From: Simon Davis
Sent: 08 March 2021 10:51
To: Tilly Whishaw [REDACTED]
Subject: RE: Y/146/20/RES - Land at Street Buildings, North End Road, Yapton

Tavy/maisonette terrace approved in application Y/39/20/RES

Title:
PLANNING LAYOUT

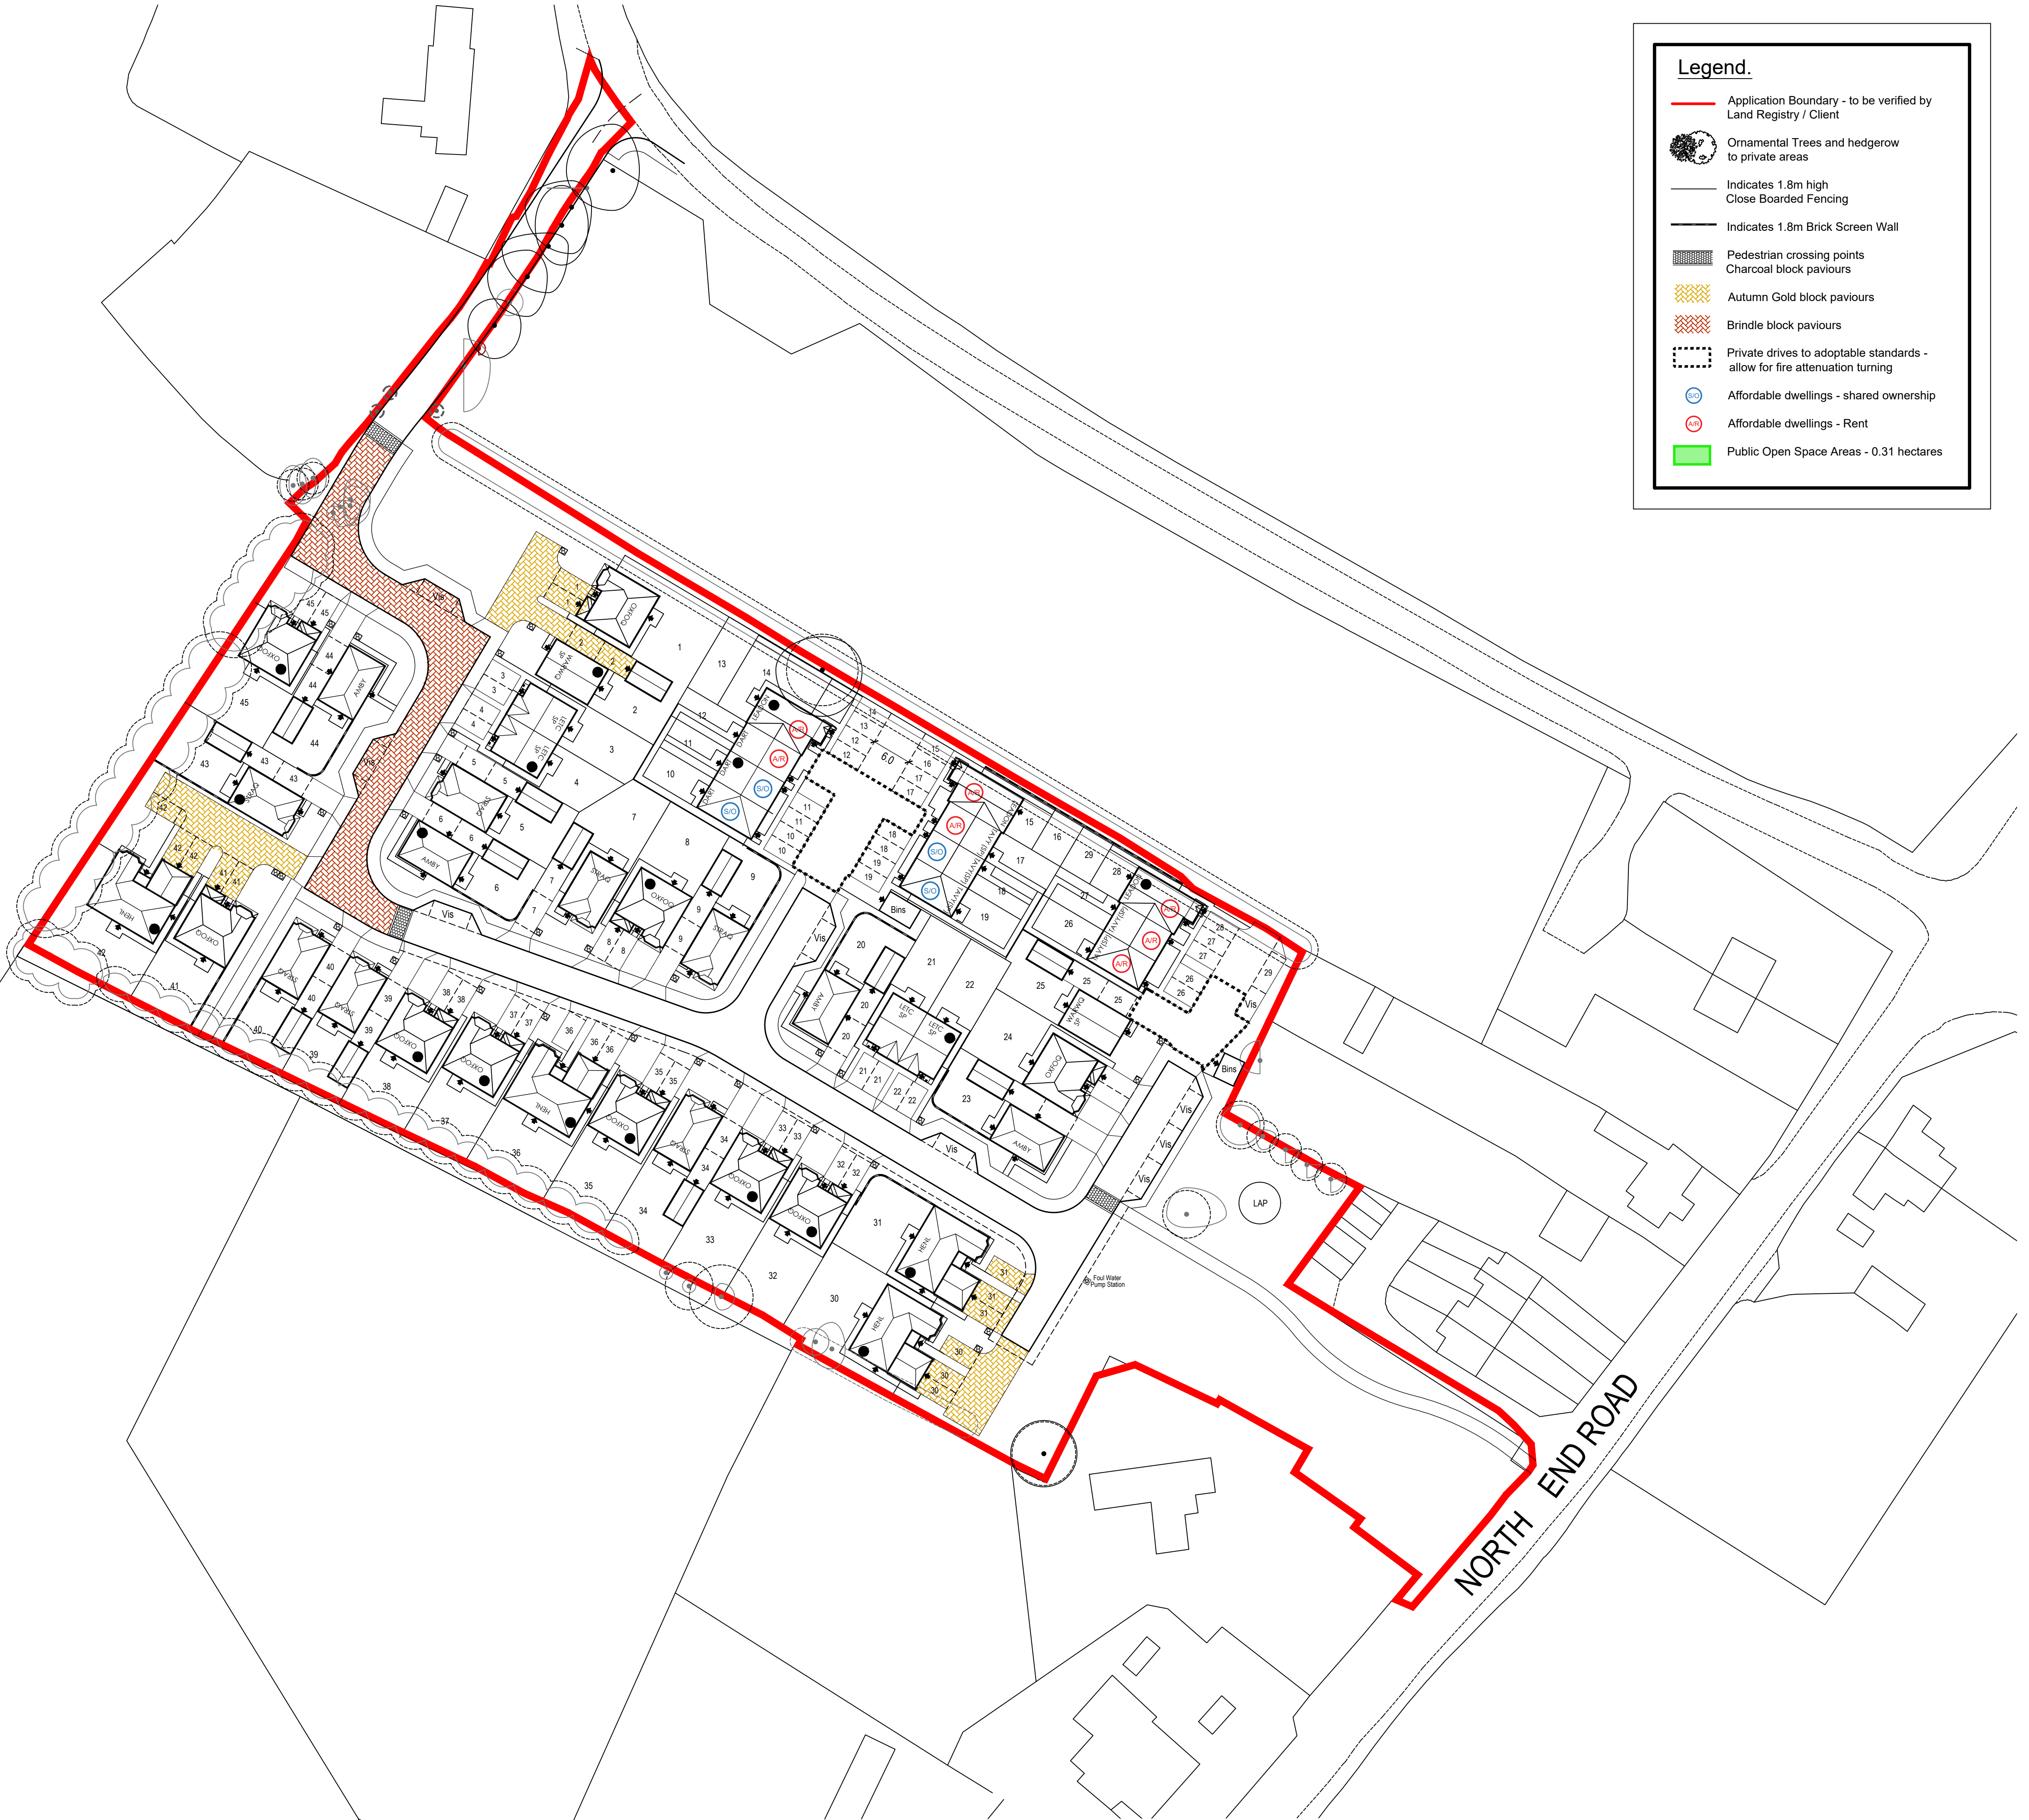
The increase in length of the Tavy does appear to eat into the depth of the rear garden (unless the extra 0.3m is to the front?)

If it is into the rear garden then I consider the following garden depths to be short versus the Design Guide:

18/19 - 9.2m long
26 - 9.5m long

However, there is not a significant difference versus the approved scheme so I feel capable of supporting the change.

Title:
TAVY - LEADON
PLANS

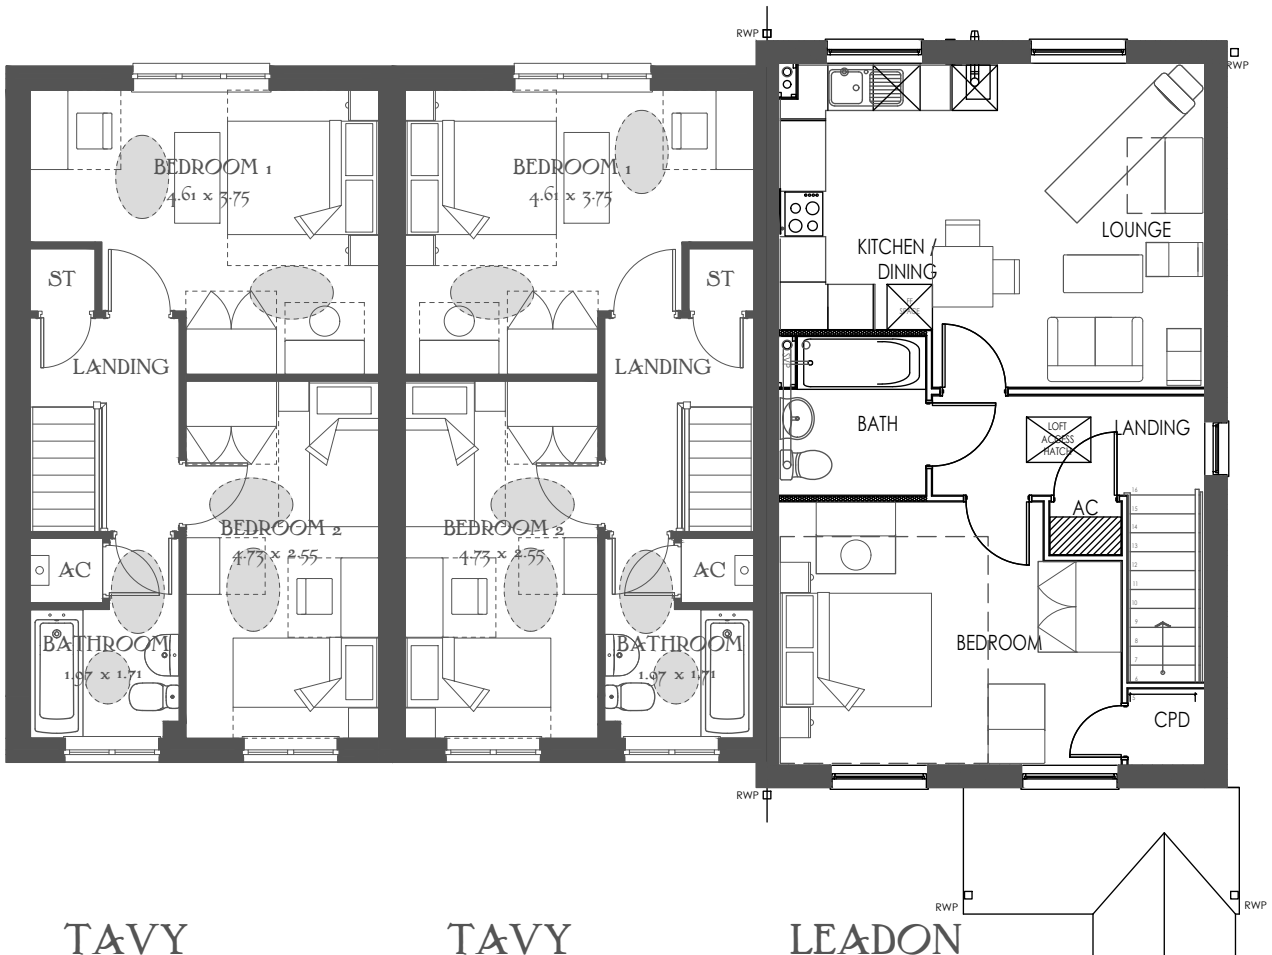
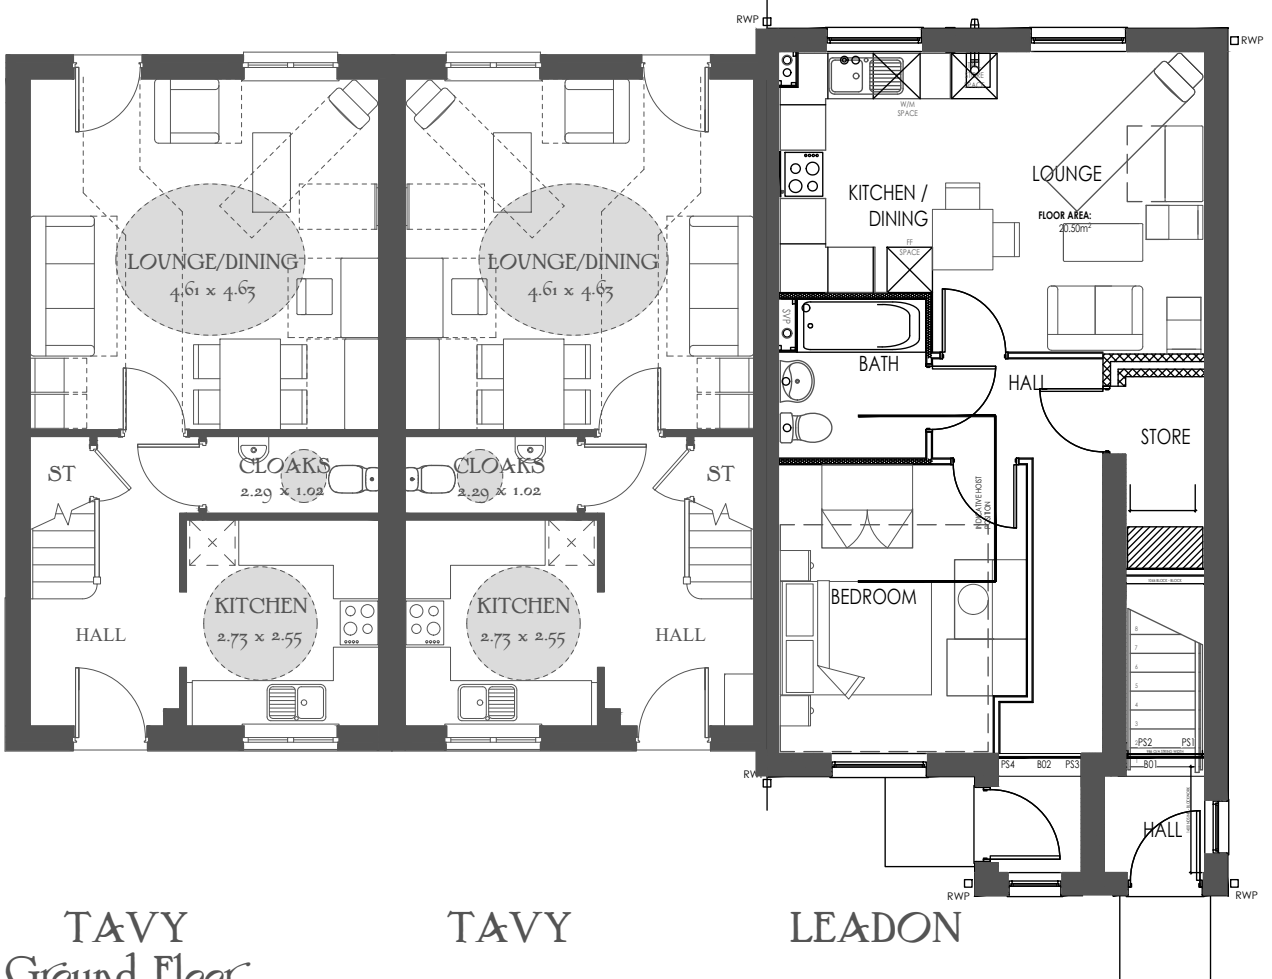
Please can you also confirm the changes in dimensions for the Tavy House types. It appears to me that the Tavy is now around 0.3m longer than before with a similar width. However, the ratio of Tavy length vs Leadon length remains the same so has the Leadon also increased in length? Please advise.

The proposed Tavy is 0.3m longer than the approved and is the same width.
